Ribble Valley Borough Council
By email

Your ref: 3/2025/0005
Our ref: DC/25/77
Date: 26-FEB-25

Location: Old Row Whalley Road Barrow BB7 9AZ

Proposal: Approval of details reserved by condition 8 (surface water drainage verification) on 3/2023/0153.

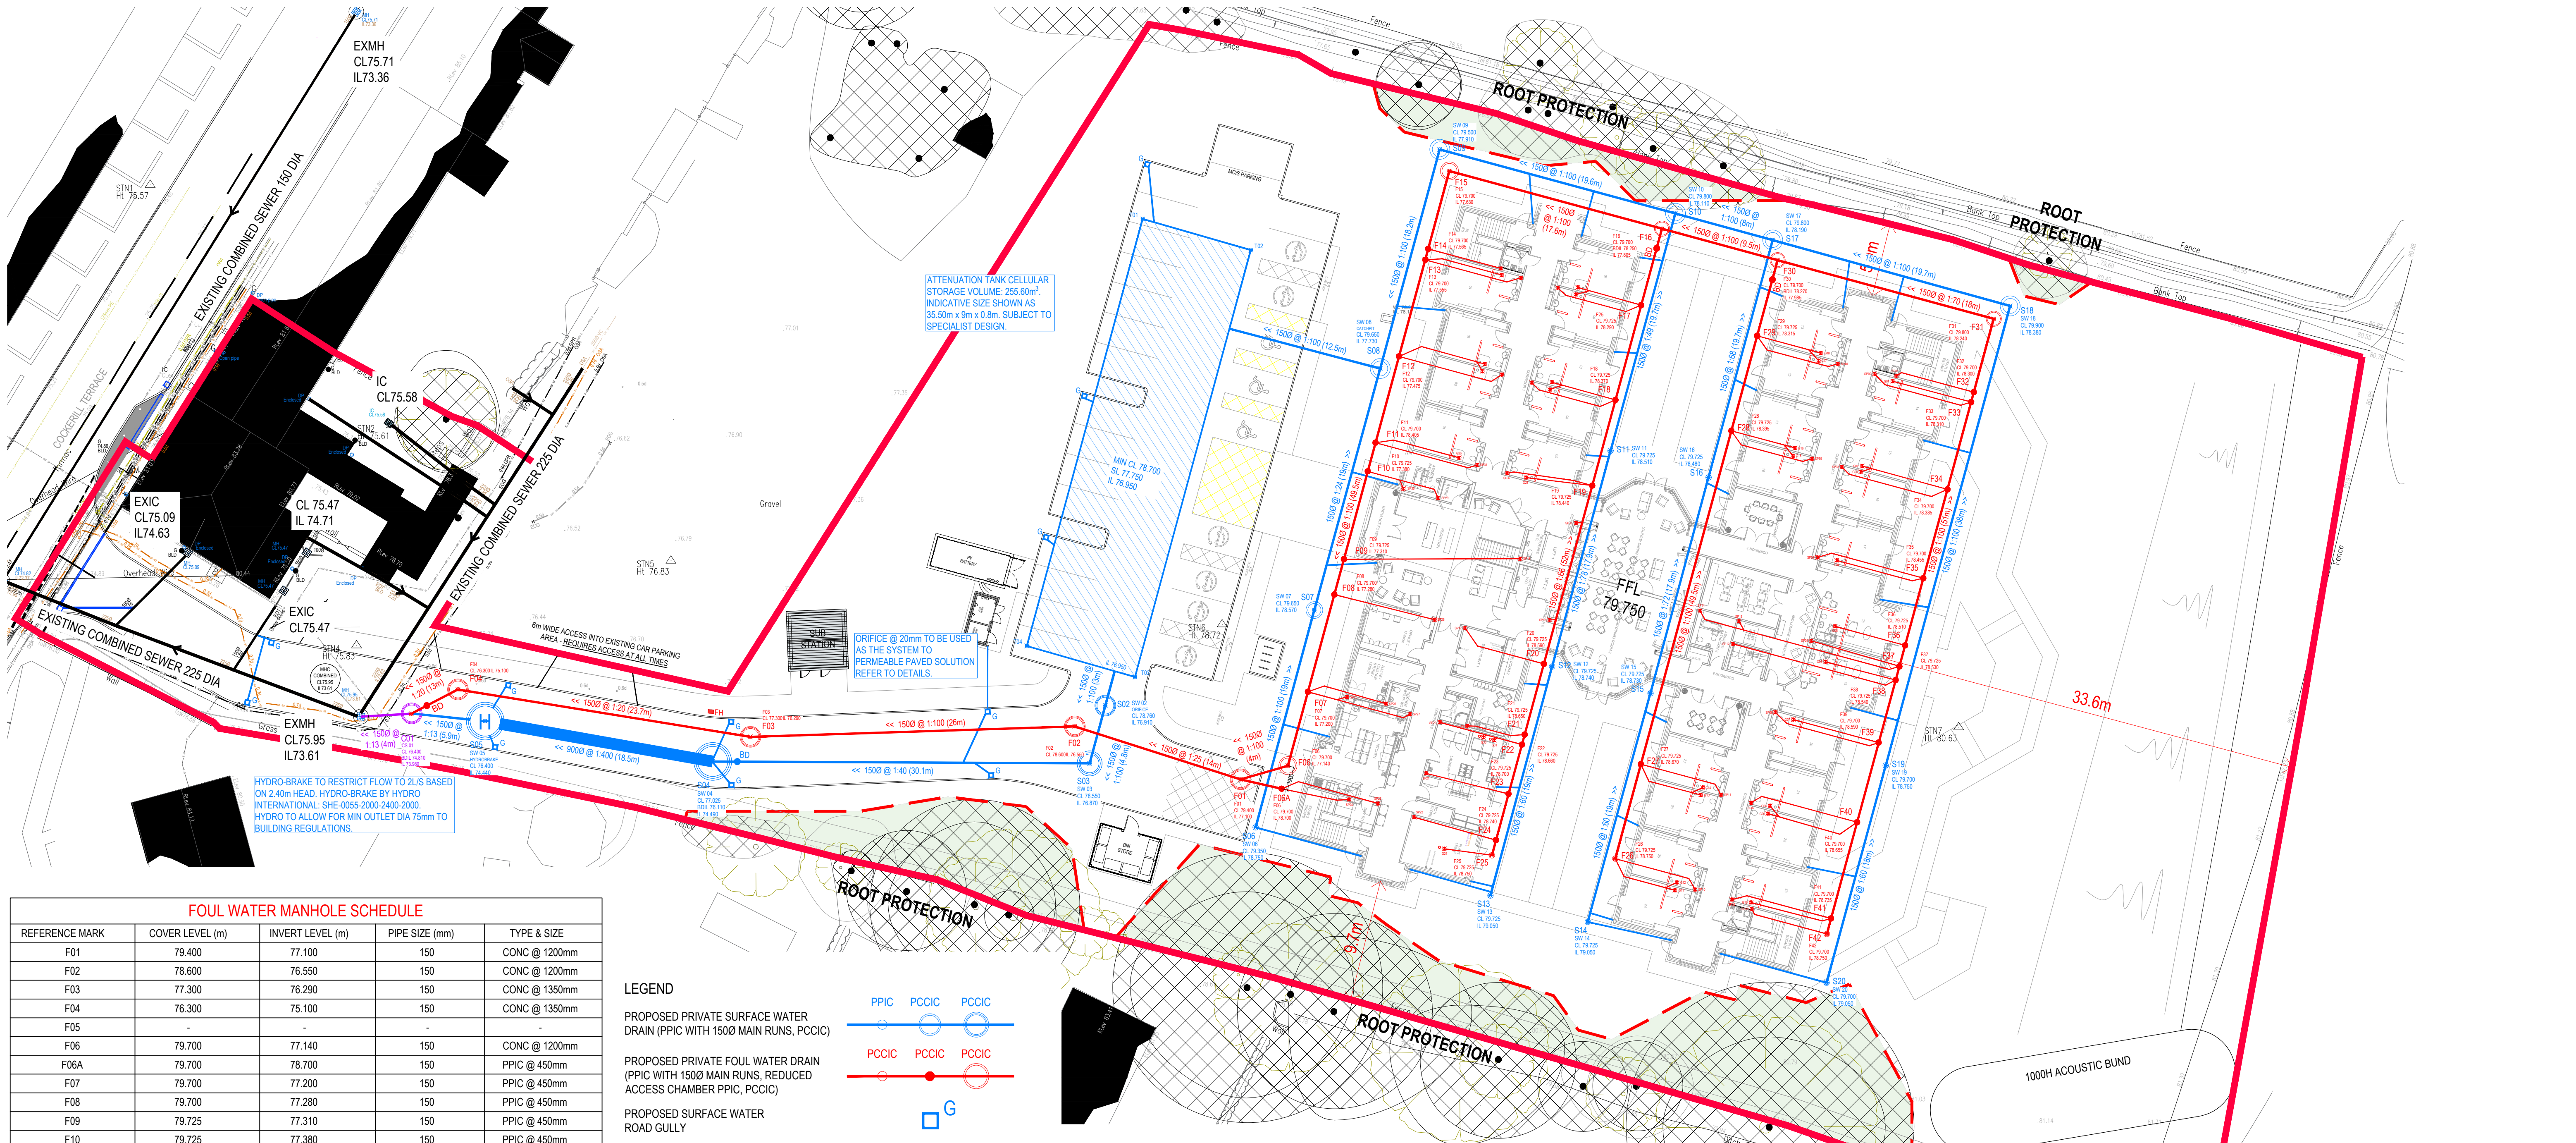
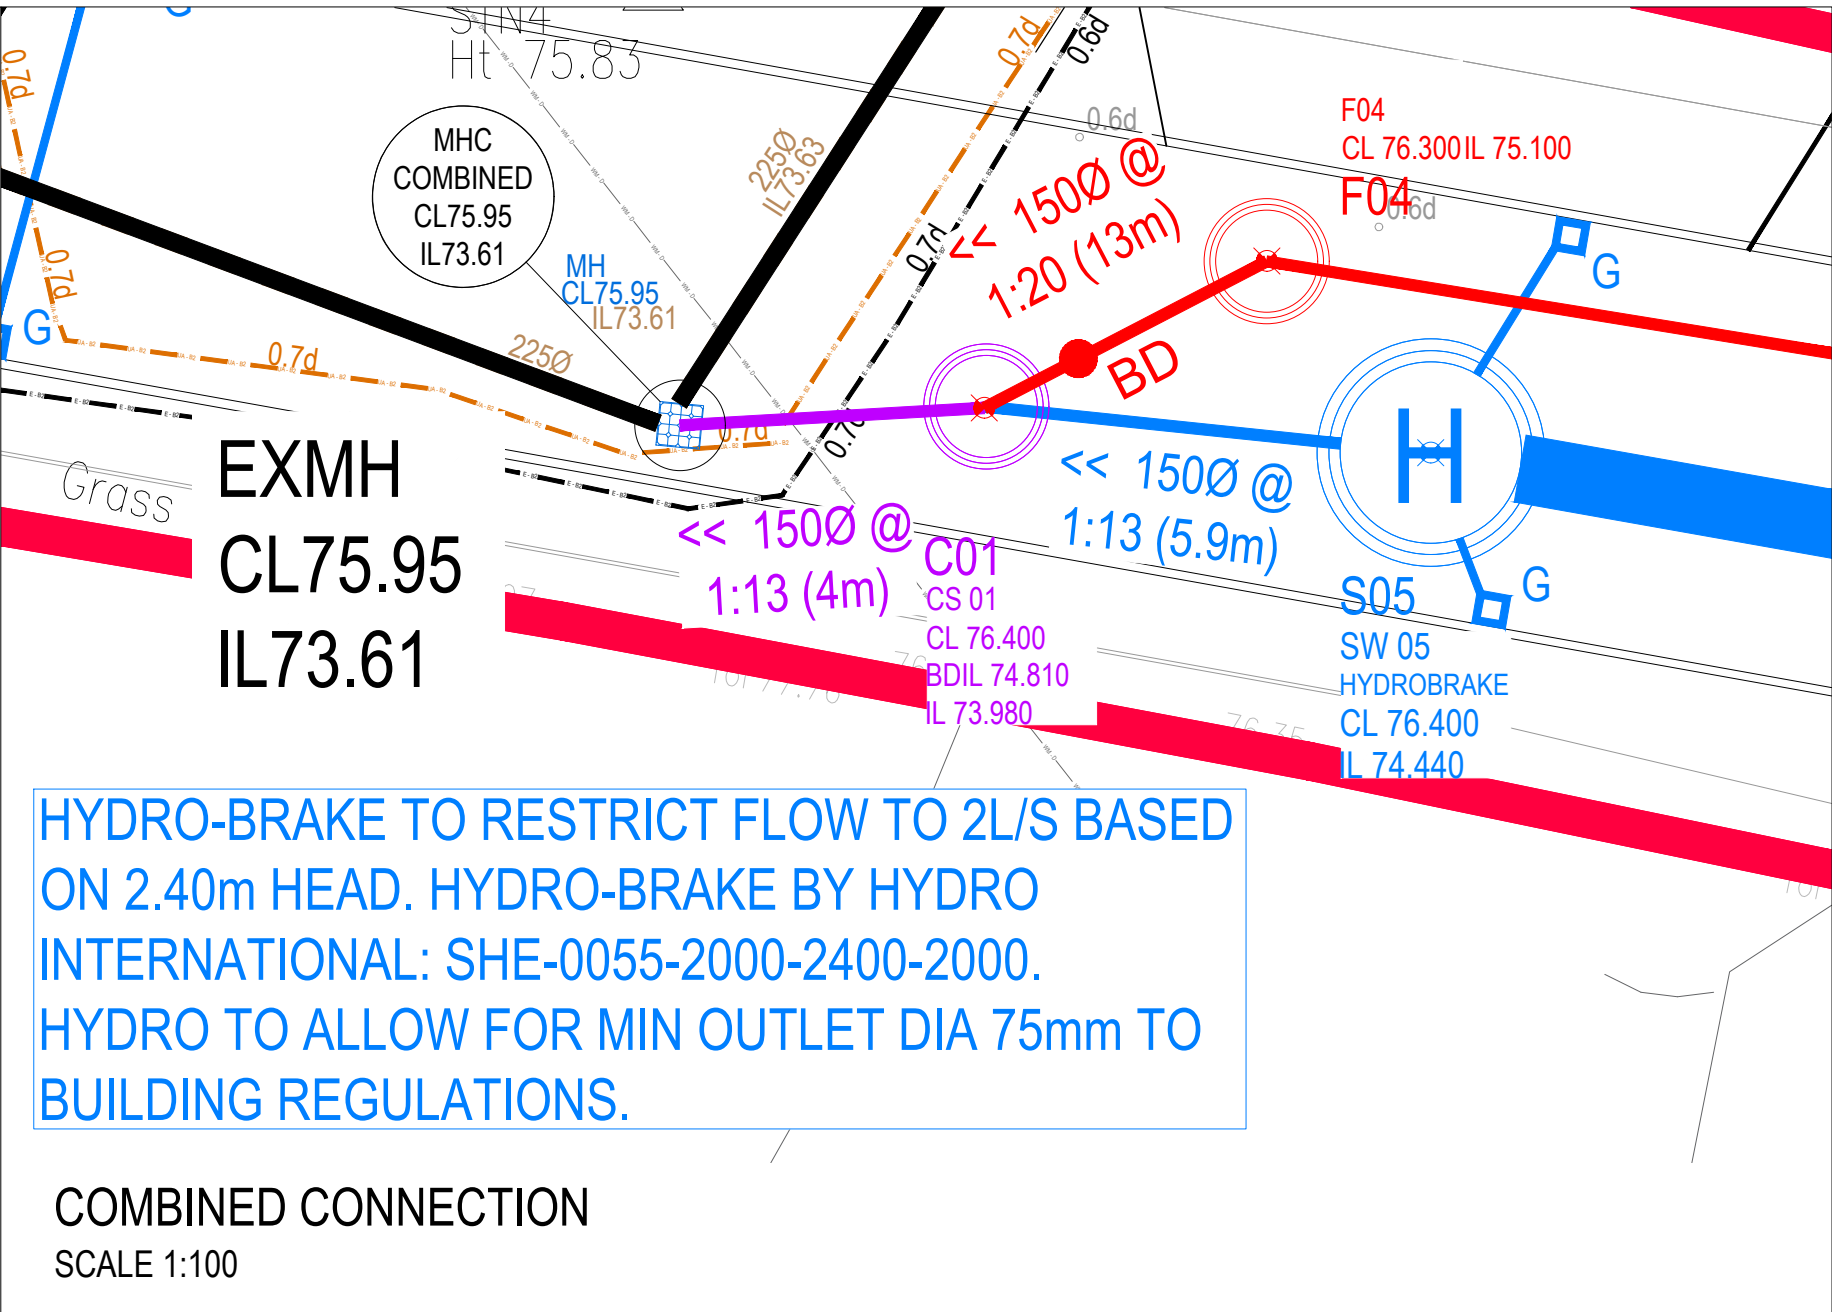
Further to our review of the submitted documents, Drawing AS Built B-03.1, - Dated 10.10.2023, United Utilities recommends that condition 8 is not discharged. This is because no evidence has been provided that the surface water hierarchy has been investigated. Please provide sufficient evidence of infiltration tests and surface water hierarchy.
